From: Nicola Moore on behalf of Planning.Responses
Sent: 21 August 2019 10:52
To: Planning Scanning
Subject: FW: Lu/321/17/PL - 22 Beach Road, Littlehampton. Application for Discharge of Planning Condition 4

Environmental Health: With reference to that document provided by Acoustic Associates, Project Number J2707, Issue One, BS 8233:2014 Assessment. This assessment would only appear to consider road noise and noise from the mechanical ventilation system to Pizza Hut. Emphasis is placed upon the fact that the food business will operate between 12:00 and 23:00 hours, with switch off of the ventilation system at 23:00 hours. The fact that the condenser unit to the walk-in chiller is positioned almost, if not immediately beneath habitable rooms to Flat One does not appear to have been included, despite the fact that this is likely to run and to cut on and off throughout any night. The report also seems to exclude consideration of the way in which rear rooms of Flat 3 may be impacted by noise from the nearby flue outlet. We would also question the assumption that mitigation would not be required in a case where one existing dwelling is converted into multiple residential unit, page 15

DRAWING TITLE:
PROPOSED FLOOR PLANS

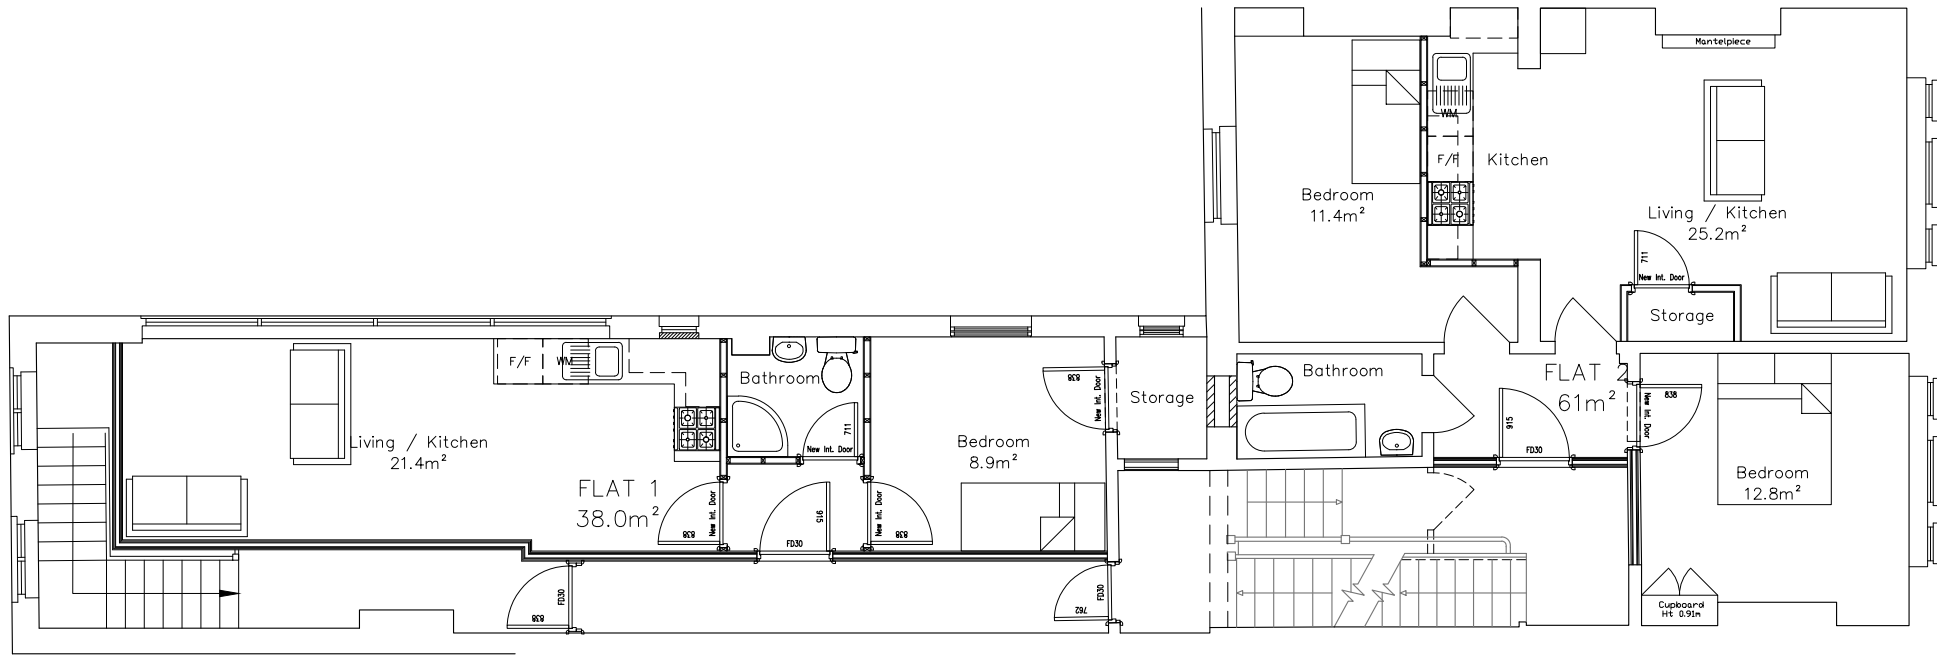
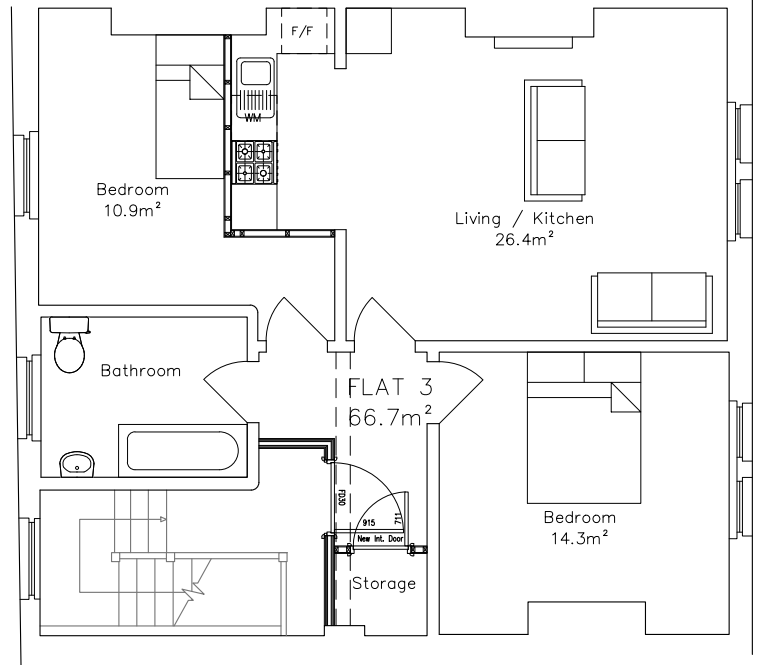
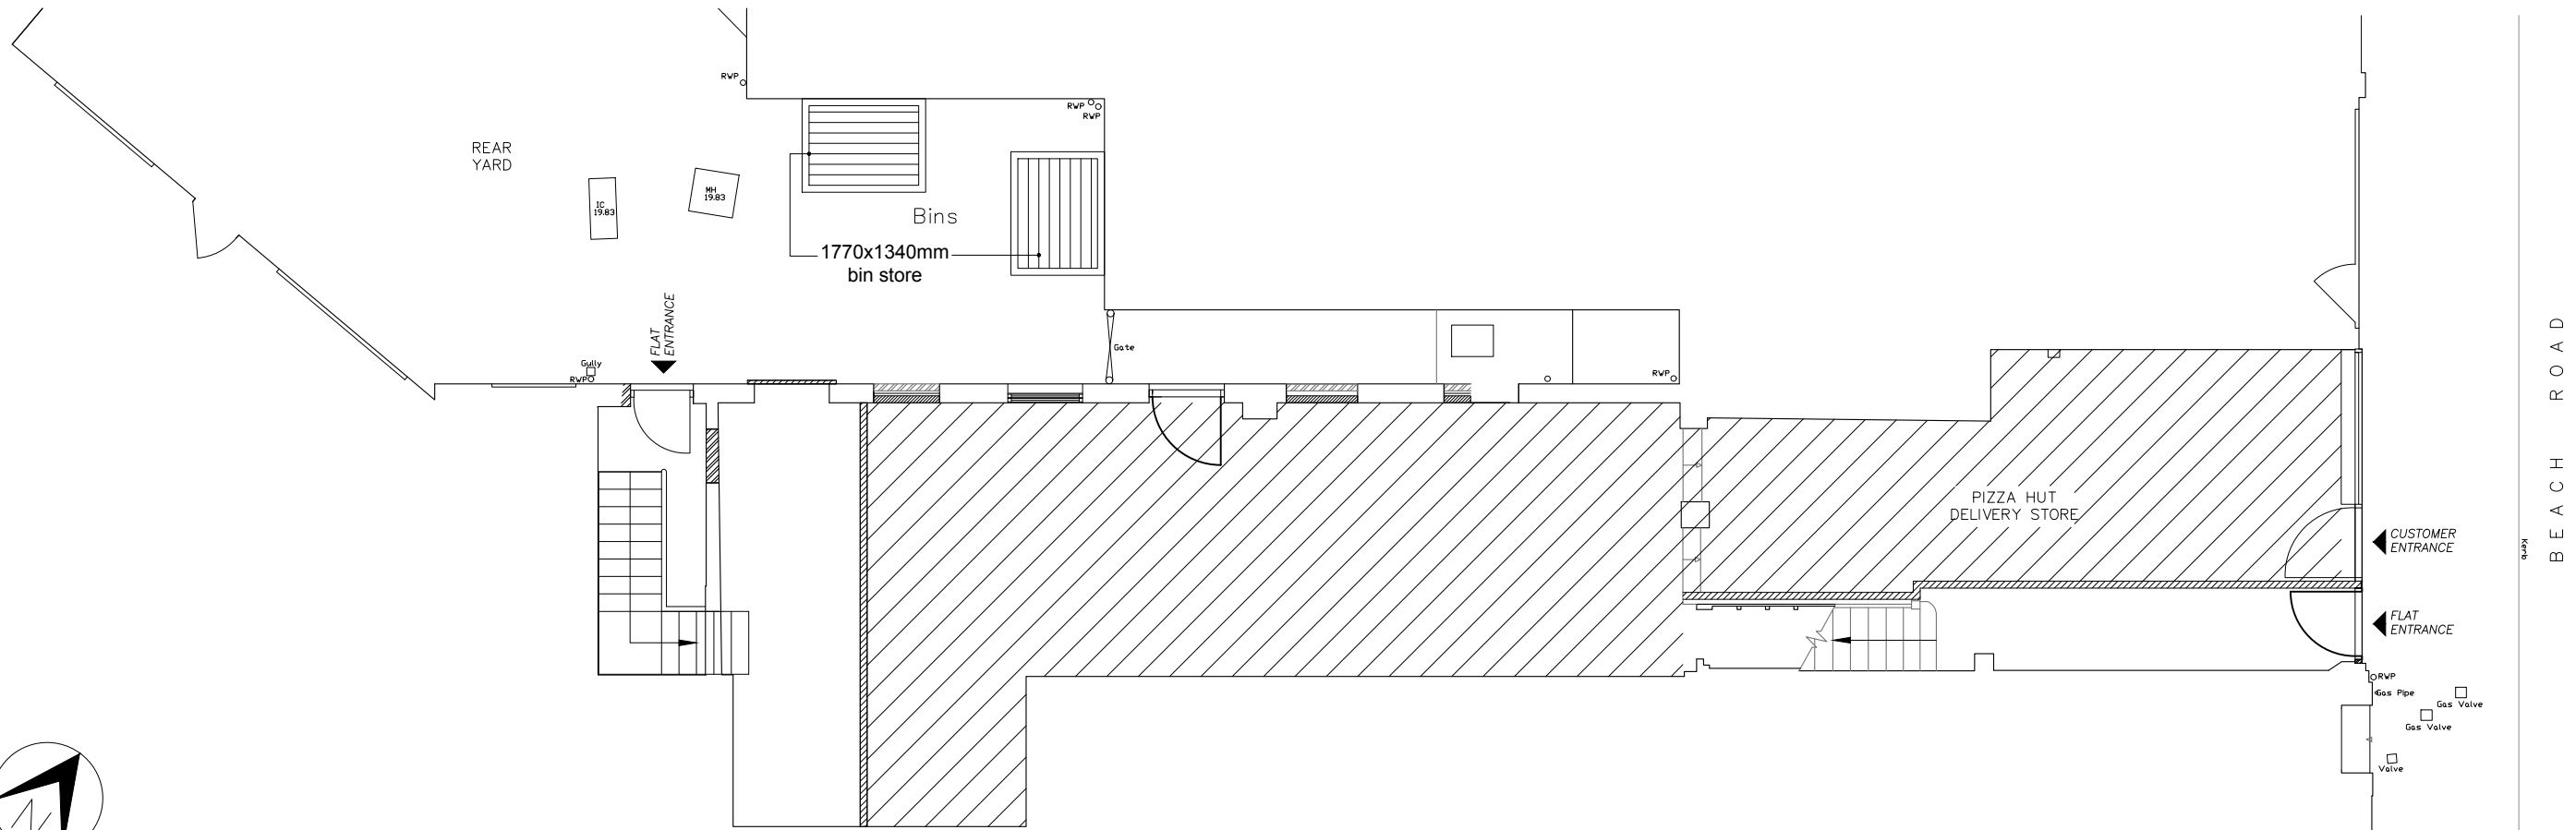
Flat 1: The report makes certain assumptions in respect of sound absorbtion once the premises is furnished. However, it also clearly states that a laminate floor will be provided meaning that sound absorbtion from soft furnishings is likely to be minimal. Average day time measurements (Figs 6 & 7, page 10) show a 'best case' scenario, indicating that with windows open (rather than closed as during the assessment period) a level of 39 to 44 dB could be expected meaning that windows would need to be kept closed if they were to comply with BS8233 guidance. Although, night time levels would appear to be acceptable, as stated intermittent condenser noise must be factored in to this calculation.

Flat 2: The assessment notes (page 6) that the site 'was already a residential dwelling' and therefore a 5dB relaxation can be allowed to guidance figures in BS8233. However, it is also to be noted that this was previously a much bigger residential unit where it would have been possible to use alternative rooms should noise from the road be unacceptable; also that those bedrooms facing the road in Flats 2 and 3 are the main, double bedrooms. I therefore see no reason why this relaxation should be applied. The fact that the assessment was carried with the windows closed means 10-15dB may be added to represent the actual noise level so that these rooms do not accord with the requirements of BS8233.

In respect of noise at the rear bedroom to flat 2, then the fact that this window was 'cracked open' seems to indicate that this does not properly reflect the situation of an 'open window.'
